**KIRKLEES METROPOLITAN COUNCIL
INVESTMENT & REGENERATION SERVICE**

**DELEGATED DECISION TO DETERMINE APPLICATIONS FOR
CONSENT, AGREEMENT OR APPROVAL REQUIRED BY CONDITION**

Reference No:	2024/44/92386/E
Site Address:	1-22, The Arcade, 14 & 16, Corporation Street, 23 & 25, Market Place, Dewsbury, WF13 1QG
Description:	Discharge details reserved by conditions 16 (signage), 17 (colour scheme) and 21 (trickle vent details) of previous permission 2023/91134 for variation condition 2 (plans) on previous permission 2021/93190 for alterations to the building and material change of use of units to flexible uses falling within Use Classes E (a), (b), (c), (d), (g(i)), (g(iii)), public house/wine bar/drinking establishment
Recommending Officer:	Louise Bearcroft

DECISION – Discharge of Conditions – Approve

DRAWING TITLE  
Hanging Signage

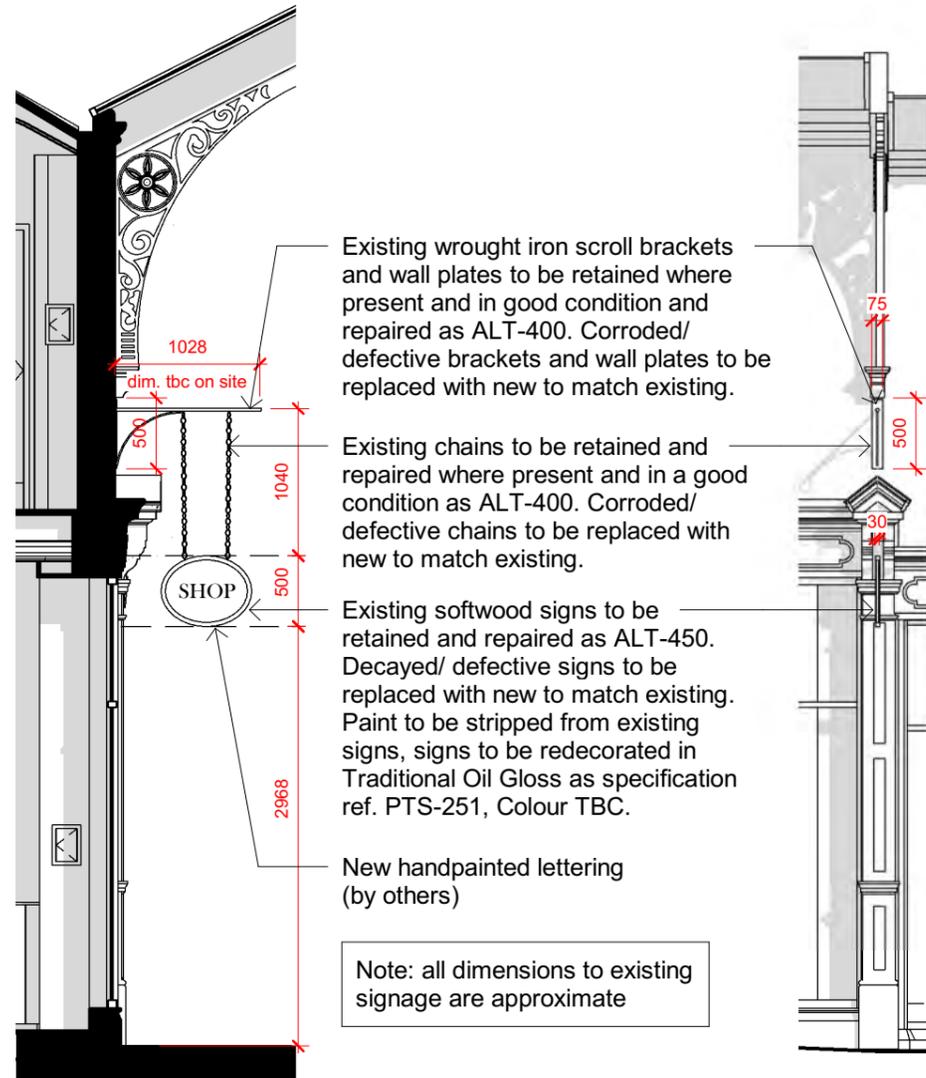
KC Conservation and Design – With regard to discharging condition 16, details have been submitted on drawing 1705-BDP-AD-00-DT-A-20005_C01. The condition was imposed to ensure that the detailing of the hanging signage does not harm the character and significance of the listed building. The information provided is detailed enough to discharge condition 16 as the details show that the existing traditional hanging signage and brackets would be refurbished where possible, with any replacement parts matching the existing to ensure a consistent approach.

KC Conservation and Design note the information provided is detailed enough to discharge condition 16, as the details show that the existing traditional hanging signage and brackets would be refurbished where possible, with any replacement parts matching the existing to ensure a consistent approach. The details are acceptable to satisfy the submission requirement of condition 16.

PROJECT TITLE Dewsbury Arcade	
BDP JOB NUMBER P3001705	
DRAWING TITLE Roof Truss Colour Scheme	SCALE @ A3 Not to scale
DRAWING NO. 1705-BDP-AD-RF-DT-A-27001	DATE FIRST ISSUED 21.08.2024
REVISION C01

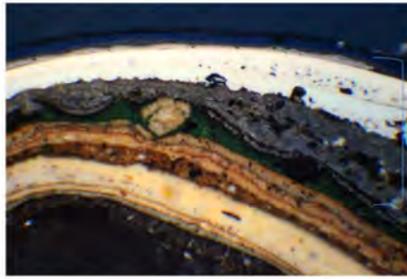
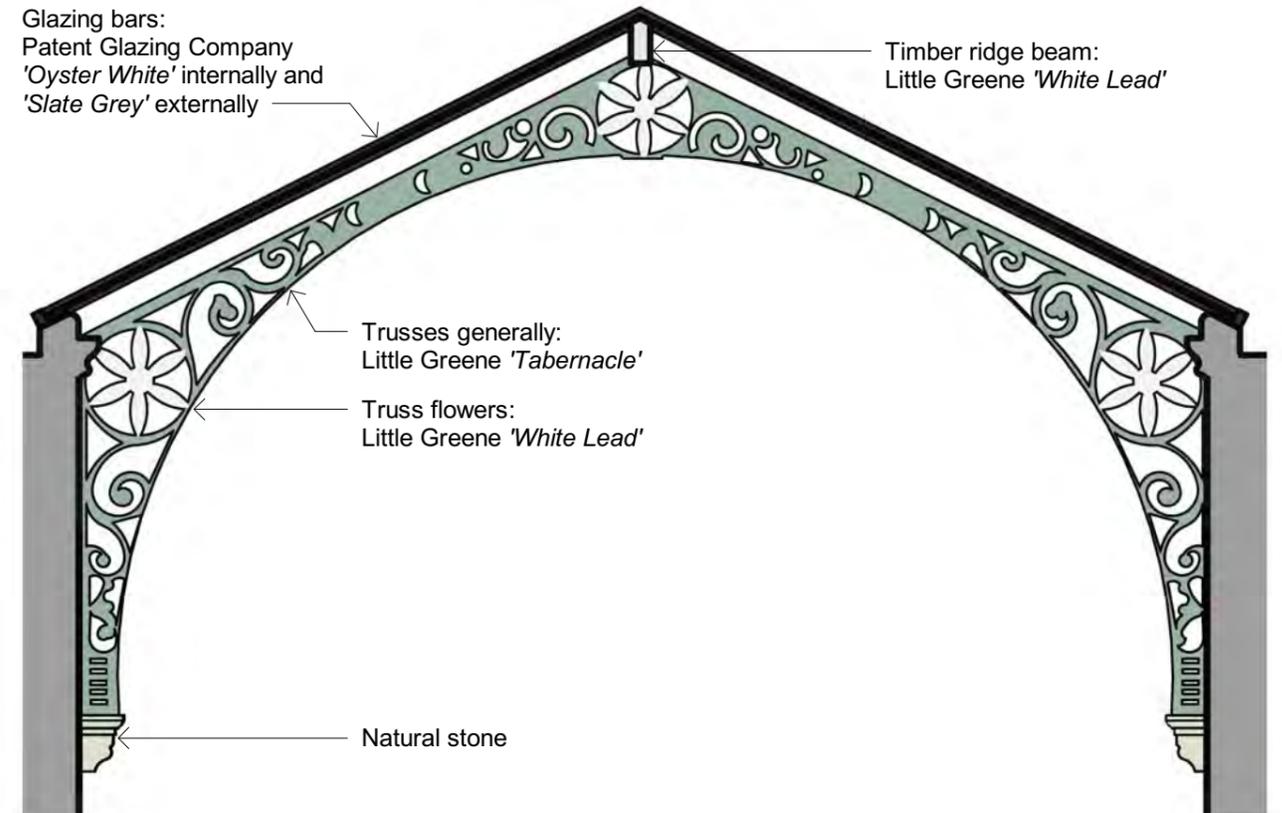
KC Conservation and Design – With regard to discharging condition 17, details have been submitted on Roof Truss Colour Scheme Details (1705-BDP-AD-RF-DT-A-27001_C01). The document includes extracts from a paint analysis showing the historic colour scheme, along with a truss detail showing the proposed colour scheme. The condition was imposed to ensure that the colour of the trusses does not harm the character and significance of the listed building. The information provided is detailed enough to discharge condition 17 as it provides evidence of the historic colours which justifies the proposed colour scheme.

KC Conservation and Design note the submitted document includes extracts from a paint analysis showing the historic colour scheme, along with a truss detail showing the proposed colour scheme. They go on to say the information provided is detailed enough to discharge condition 17 as it provides evidence of the historic colours which justifies the proposed colour scheme. The details are acceptable to satisfy the submission requirement of condition 17.

DRAWING TITLE
Window Trickle Vents

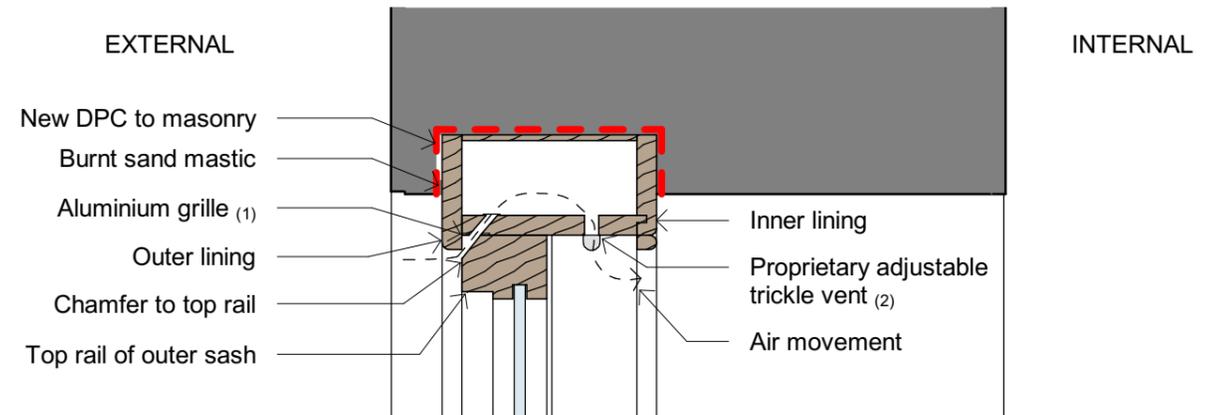
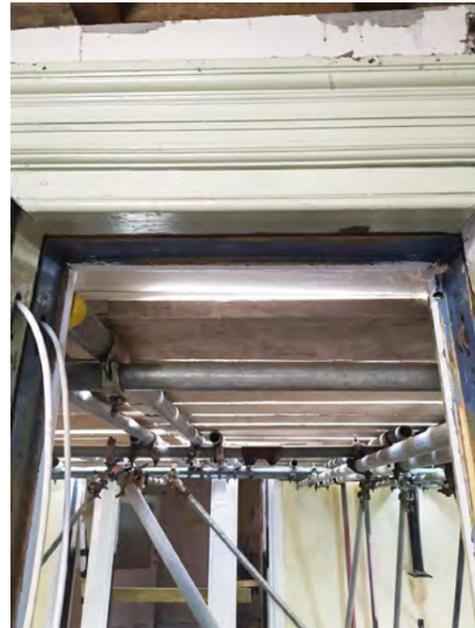
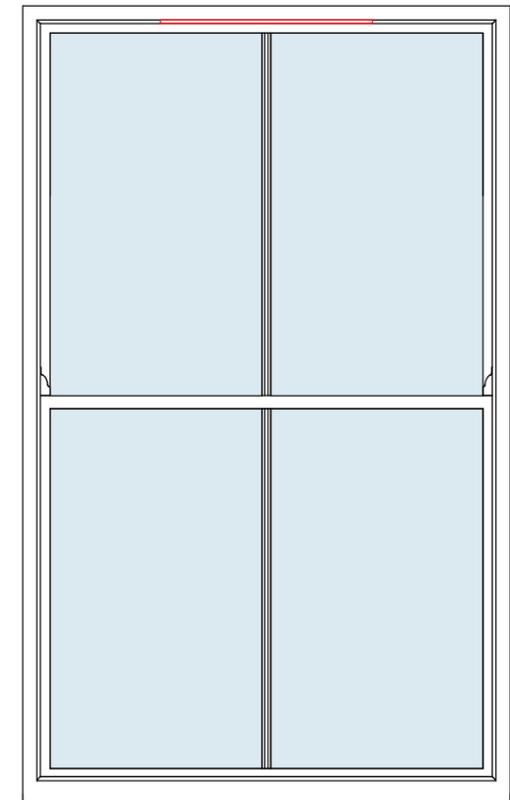
KC Conservation and Design – With regard to discharging condition 21, details have been submitted in drawing 1705-BDP-AD-XX-DT-A-31104_C01. This submission includes images of a sample sash window which would be altered to incorporate the proposed trickle vents. A construction detail drawing shows that slots would be cut out of the frame head, with an adjustable trickle vent fitted to the internal frame head and an aluminium grille fitted above the top sash. A small section of the top sash frame would be chamfered, allowing airflow to enter the room via the grille and trickle vent. The condition was imposed to ensure that the trickle vents do not harm the character and significance of the listed building. The information provided is detailed enough to discharge condition 21 as it demonstrates that background ventilation can be provided with very little impact on the significance of the sash windows. KC Conservation and Design consider that the information submitted is sufficient to assess the impact upon the character and significance of the listed building and the details are found to be satisfactory.

KC Conservation and Design note the submission includes images of a sample sash window which would be altered to incorporate the proposed trickle vents. A construction detail drawing shows that slots would be cut out of the frame head, with an adjustable trickle vent fitted to the internal frame head and an aluminium grille fitted above the top sash. A small section of the top sash frame would be chamfered, allowing airflow to enter the room via the grille and trickle vent. KC Conservation and Design go on to say the information provided is detailed enough to discharge condition 21 as it demonstrates that background ventilation can be provided with very little impact on the significance of the sash windows.
